# OXFORDSHIRE COUNTY COUNCIL'S RESPONSE TO CONSULTATION ON THE FOLLOWING DEVELOPMENT PROPOSAL

**Application no:** 23/00214/REM

**Proposal:** Reserved Matters Application pursuant to Outline planning permission 14/02121/OUT for infrastructure comprising two junctions to providing vehicular and pedestrian access into the site from Middleton Stoney Road and two initial sections of internal road

**Location:** Proposed Himley Village North West Bicester, Middleton Stoney Road, Bicester

TITLE MIDDLETON STONEY ROAD, MAIN SPINE ROAD JUNCTION. GENERAL ARRANGEMENT SHEET 1	
HYDROCK PROJECT NO. C-27141-C	SCALE @ A2 1 : 500
STATUS DESCRIPTION INFORMATION	STATUS S2
DRAWING NO. (PROJECT CODE-ORIGINATOR-ZONE-LEVEL-TYPE-ROLE-NUMBER) 27141-HYD-XX-XX-DR-D-0001	REVISION P01

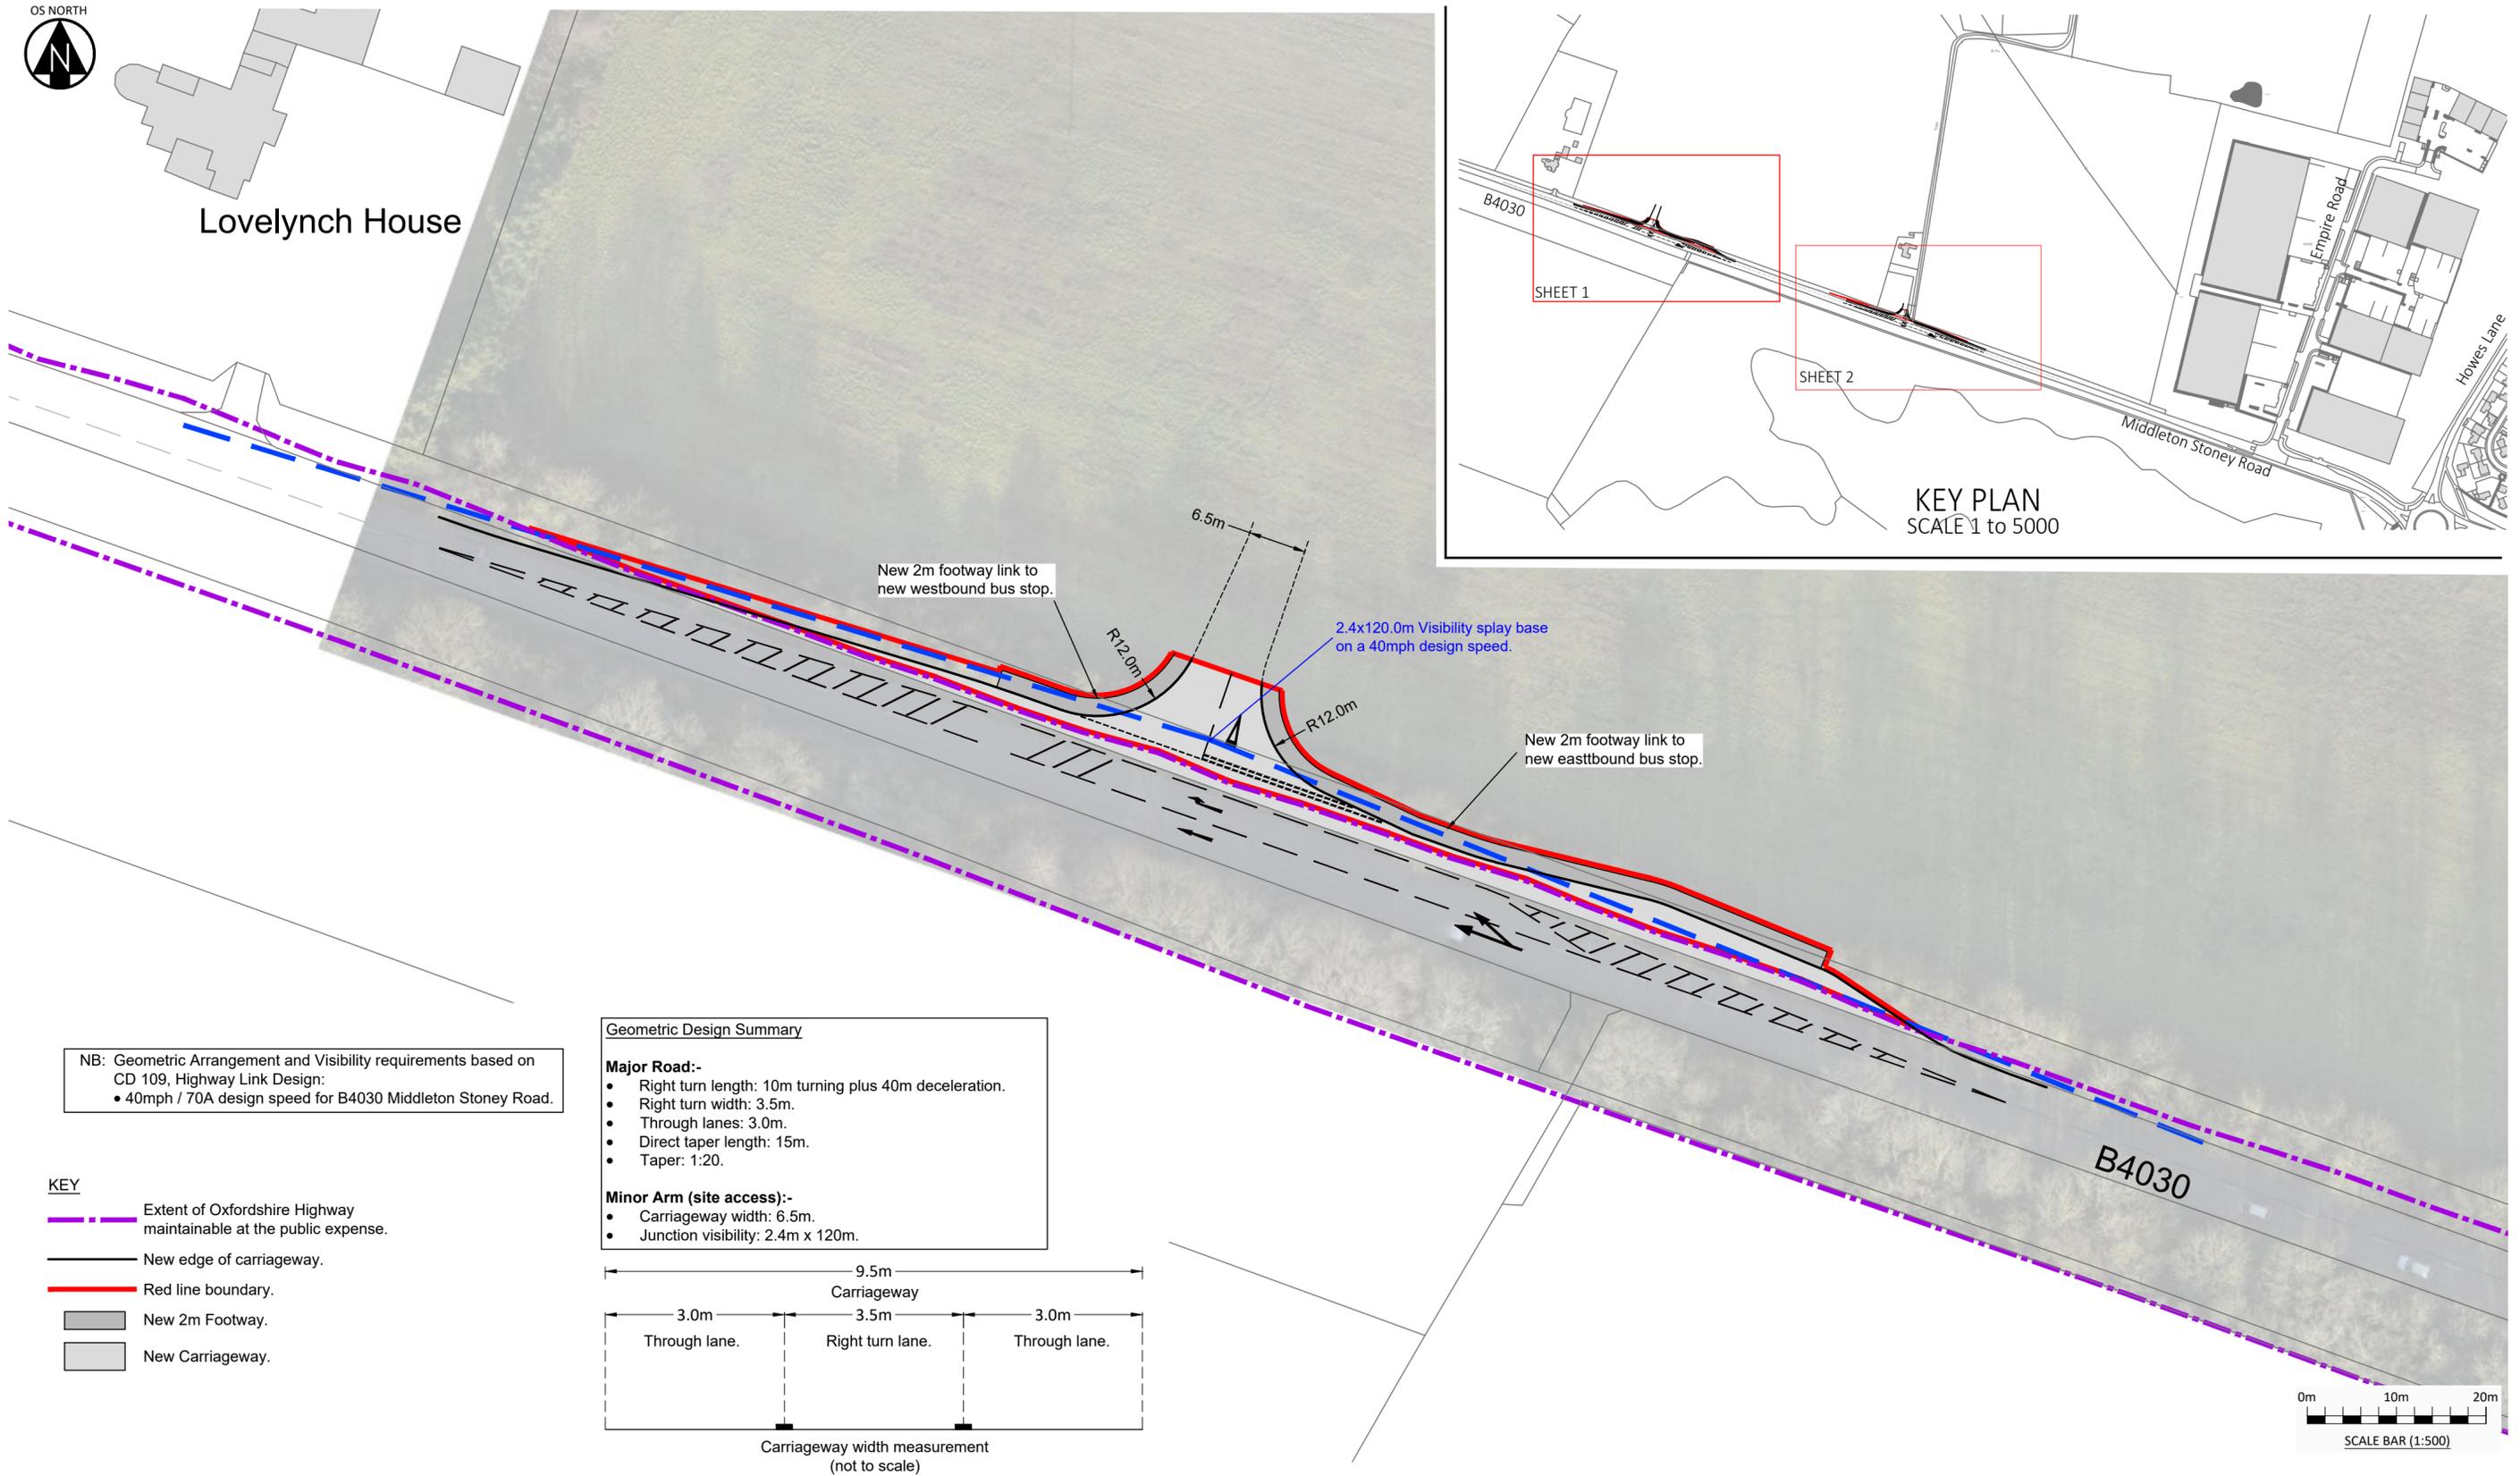
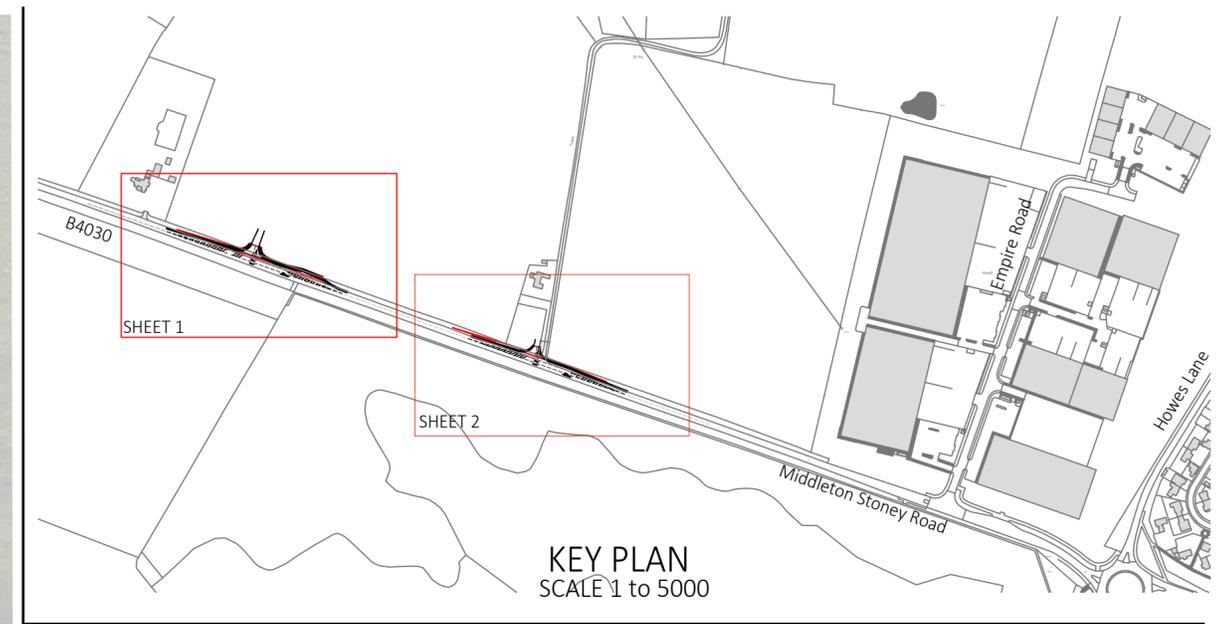
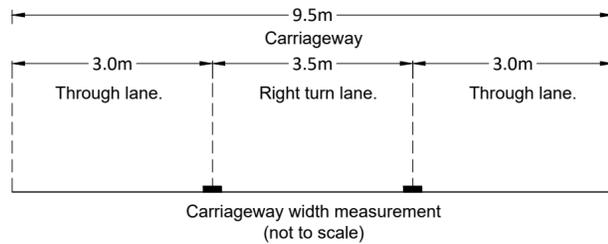
Cycle facilities will be set back from Middleton Stoney Road, behind a swale, so do not enter into the red line area of this application.

Details of the access will be finalised during the technical approval process of the Section 278 application.

TITLE
MIDDLETON STONEY ROAD,
SECONDARY ROAD JUNCTION.
GENERAL ARRANGEMENT
SHEET 2

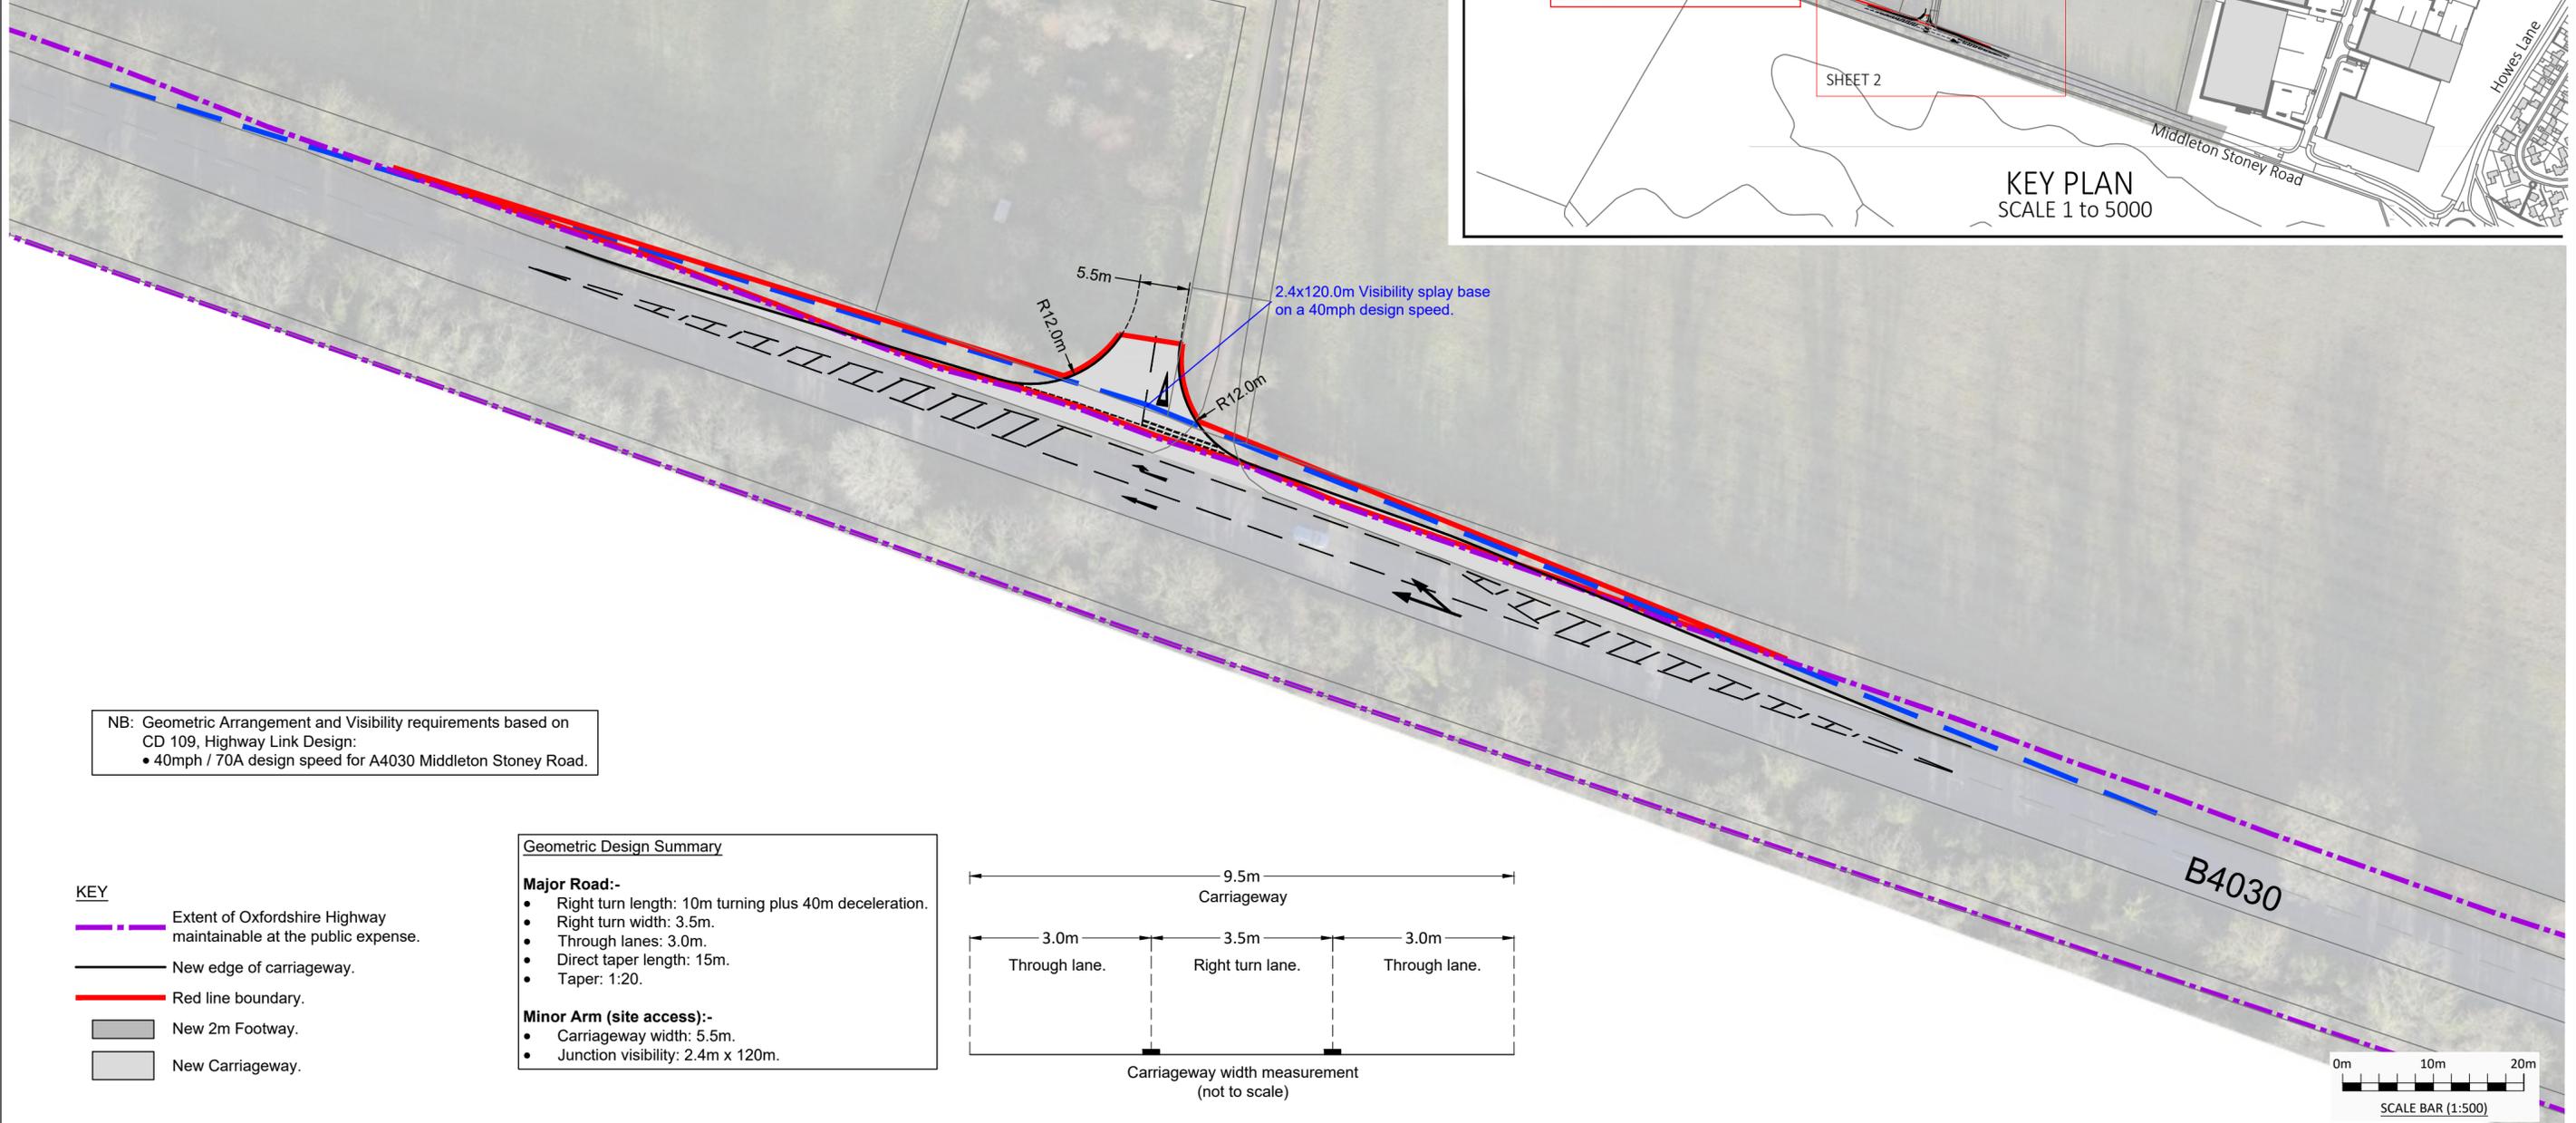
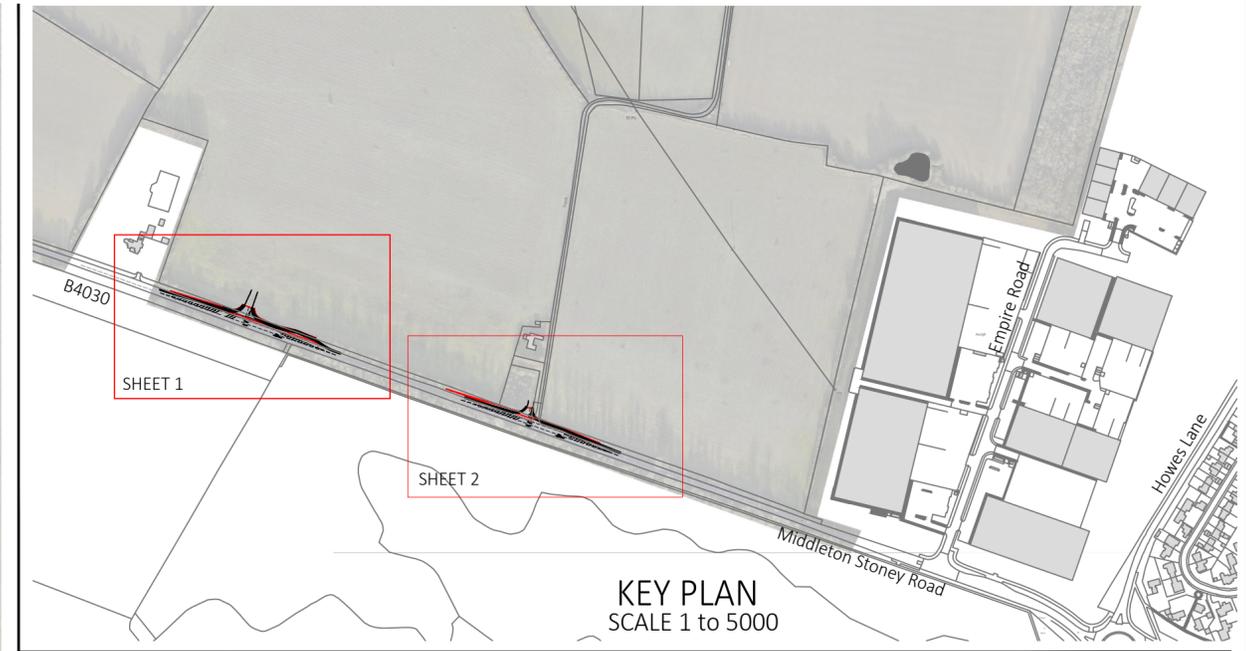
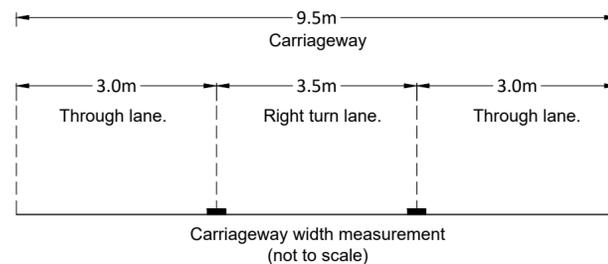
- The secondary access is insufficiently wide.

The same comments apply as for the spine road junction. However, the secondary road access must be a minimum of 6.5m wide to accommodate two-way bus movement, as it is expected that buses to/from Heyford Park will use both accesses in the future early stages of Himley Village development. A width of 5.5m is not acceptable and is a reason for objection.
